# City of Albuquerque Stormwater Construction Site Inspection Report

ESC File No.	M09E012B	Project Name:	98th & Sage Storage Frontera		
NPDES Id. No.	NMRT0066R	Location:	9850 De Vargas Rd SW		
6/17/2024	Owner		Contractor		
Operator	FRE Albuquerque SS, LLC				
Contact name & title	Brian Grissinger & Todd Megrath		David Harvey & Ian Ring		
e-mail	<a href="mailto:bryan@frontearealestate.com">bryan@frontearealestate.com</a>		913902		
Contact Phone #	619-756-4622		913-302-7409		
COA Inspector	James Hughes		Start/End Time:	11:30AM	
Construction Phase:	verticals, utilities				
Type of Inspection:	Regular	Storm Event	Post Storm Event >0.25"	311/Complaint	Follow Up
Weather at time of inspection?	Clear		Temperature:	~ 95	
Estimated date of last storm 0.25" or greater	4/17/2024

SEDIMENTATION/SILT FENCE WITH WIRE SUPPORT  
N.T.S. (SF)

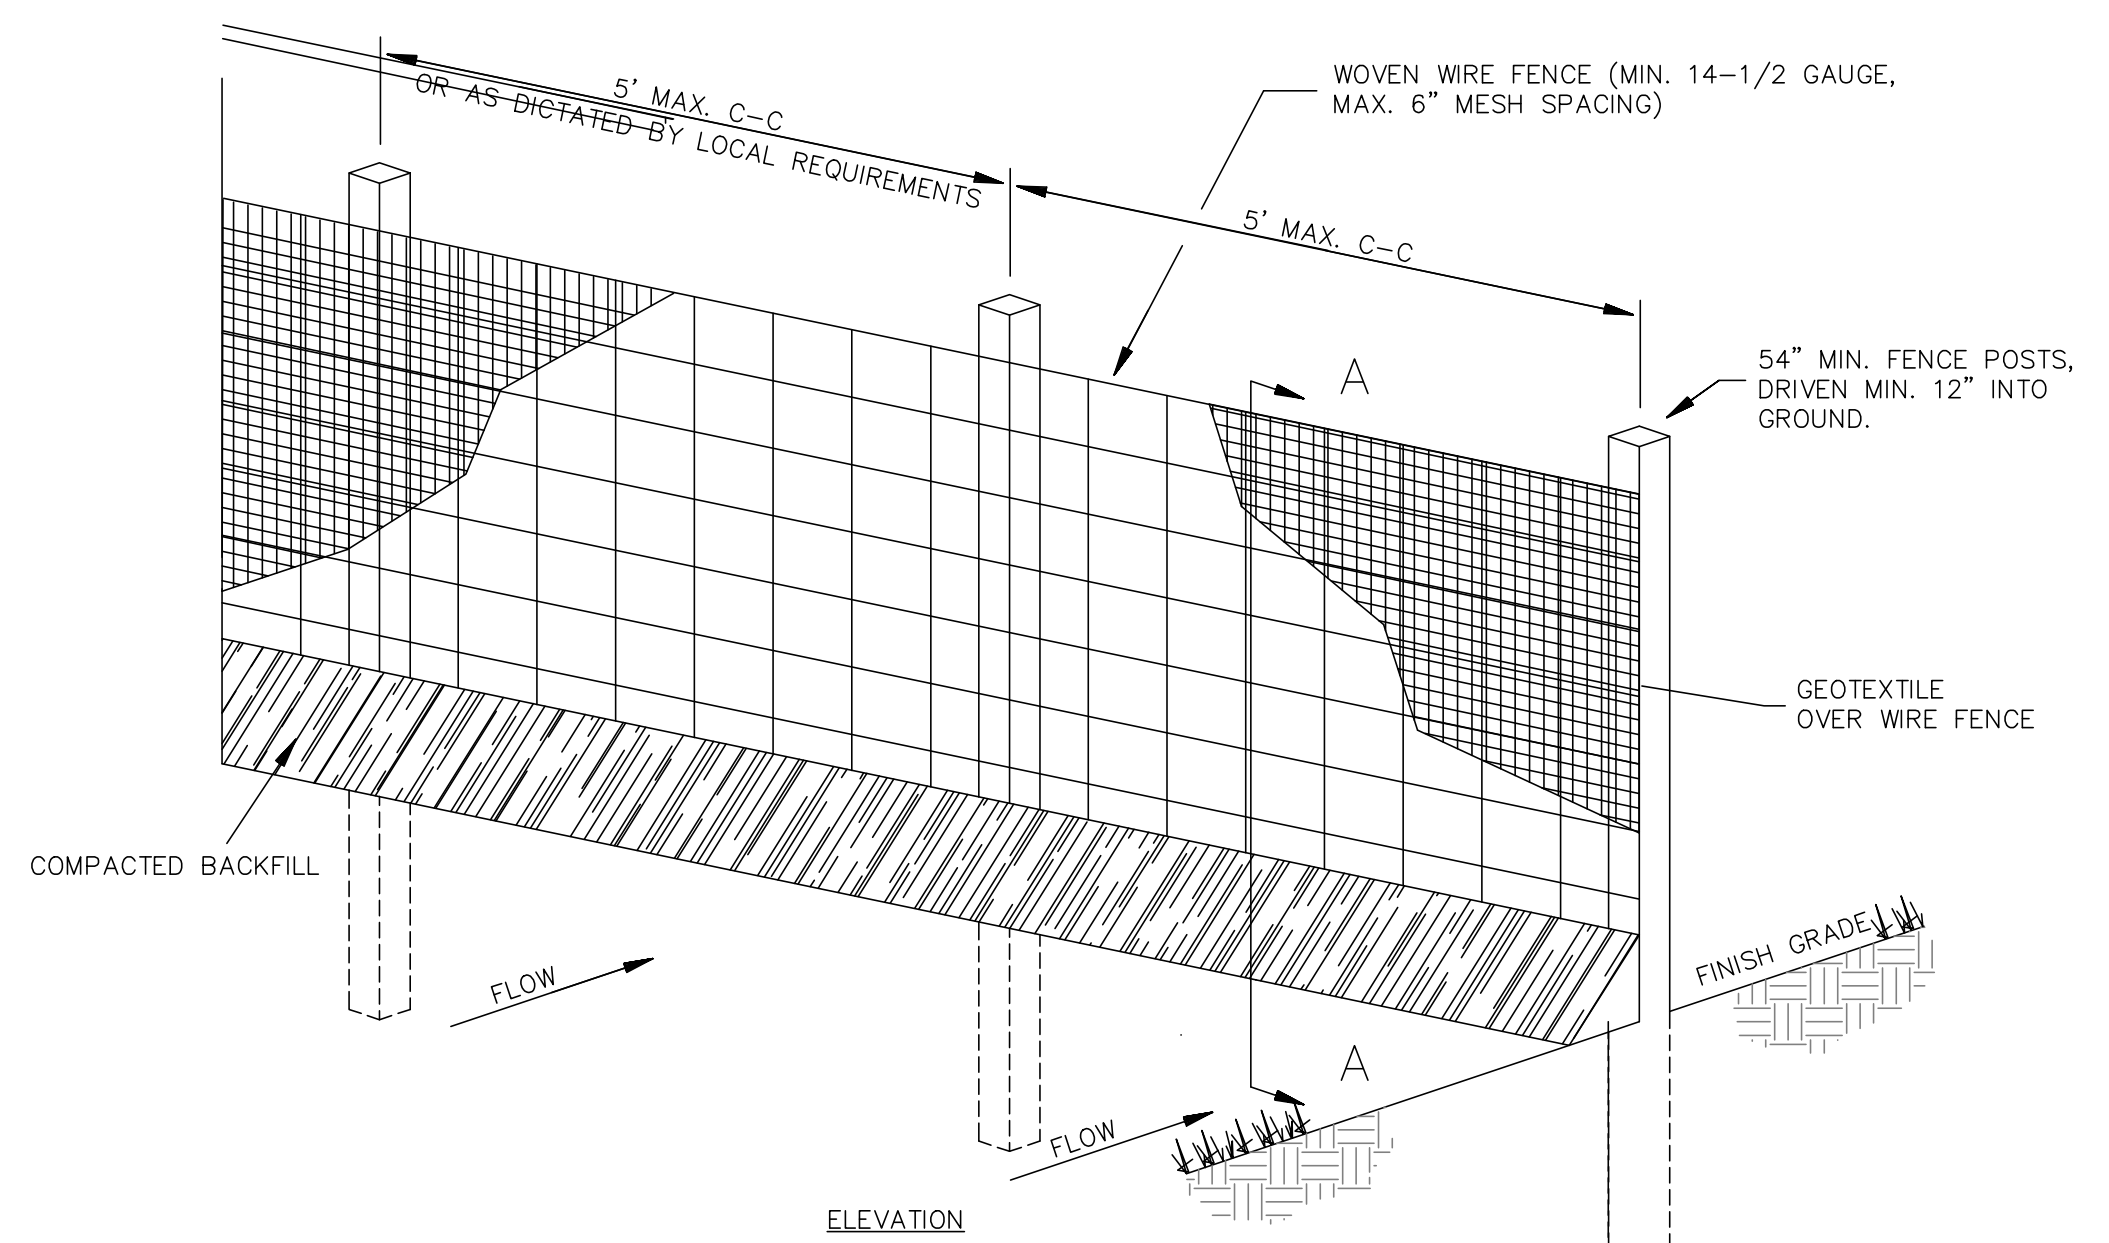
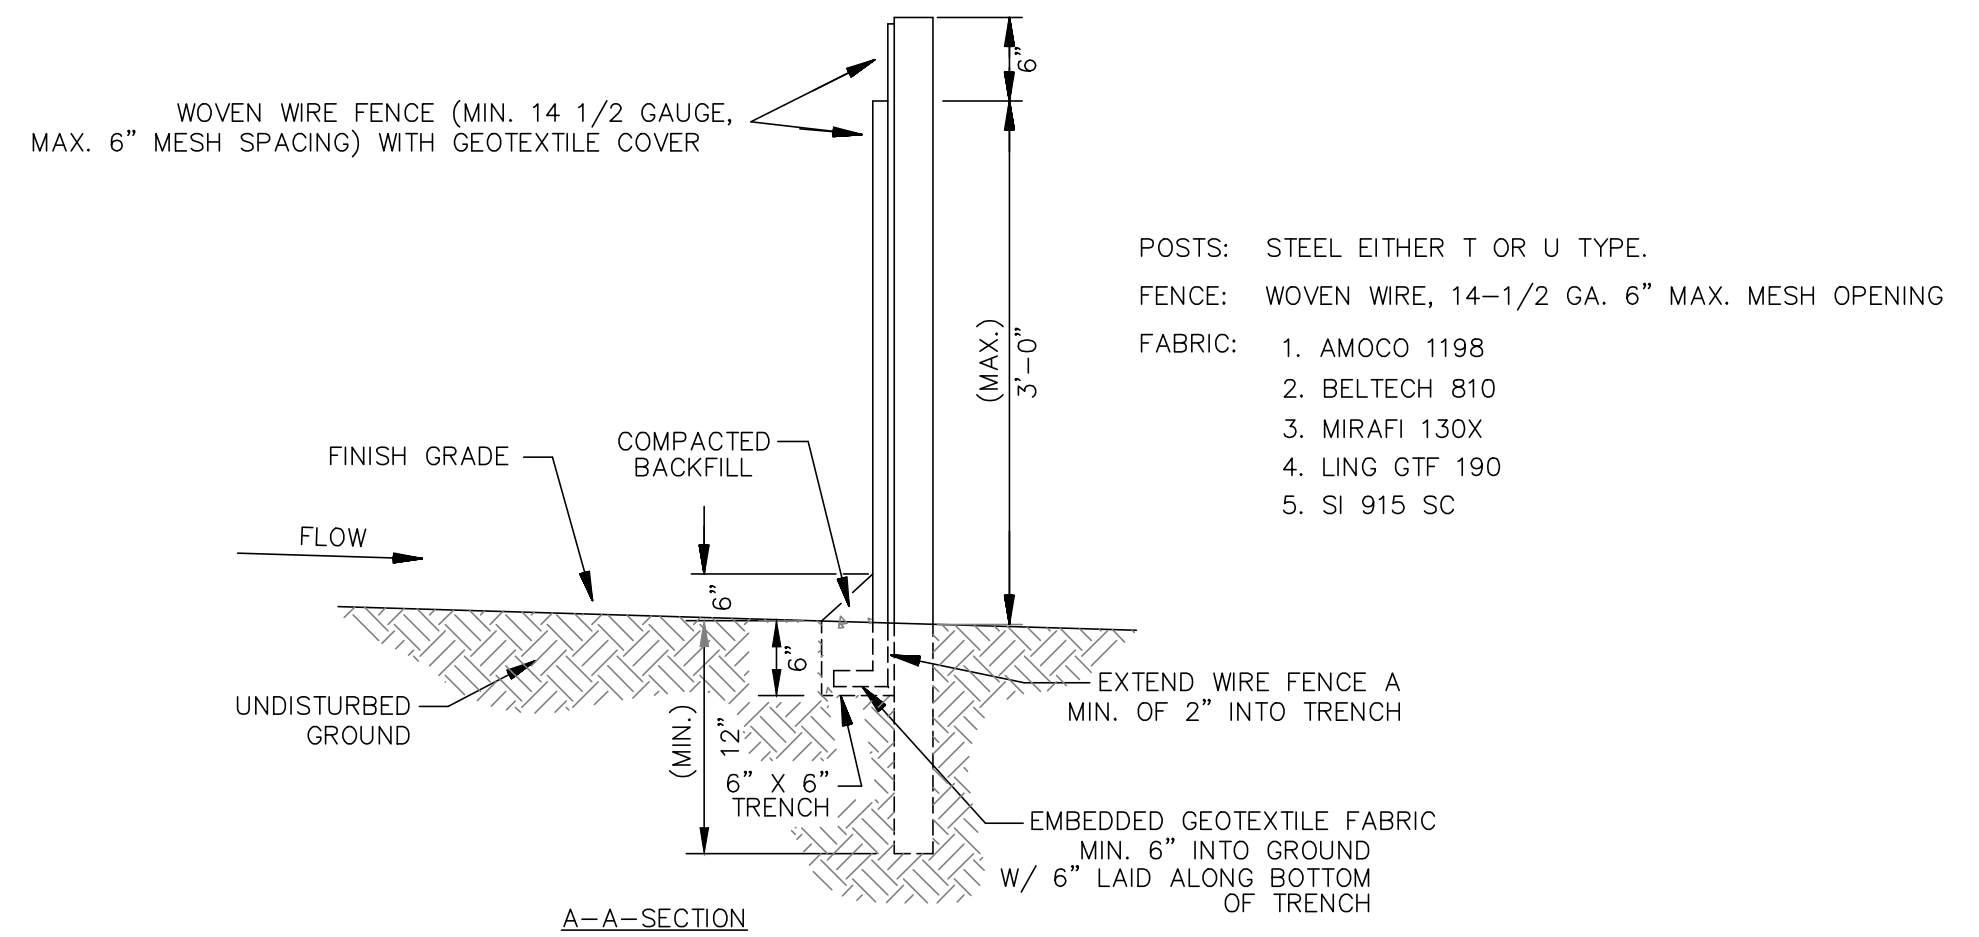
Item Number	Deficiency/ Corrective Action				
1	<b>BMPs</b> - Dirt is more than half the height of the SiltFence on the east side of the site, halfway between the pond and the stabilized exit. <b>Required Mitigation:</b> Ensure that all stormwater controls (BMPs) are maintained and remain in effective operating condition during permit coverage per CGP 2.1.4. If at any time you find that a stormwater control needs routine Maintenance, you must immediately initiate the needed maintenance work and complete such work by the close of the next business day per CGP 2.1.4.b. When the problem requires a new or replacement control or significant repair, install the new or modified control and make it operational or complete the repair by no later than seven (7) calendar days from the time of discovery per CGP 5.2.1.
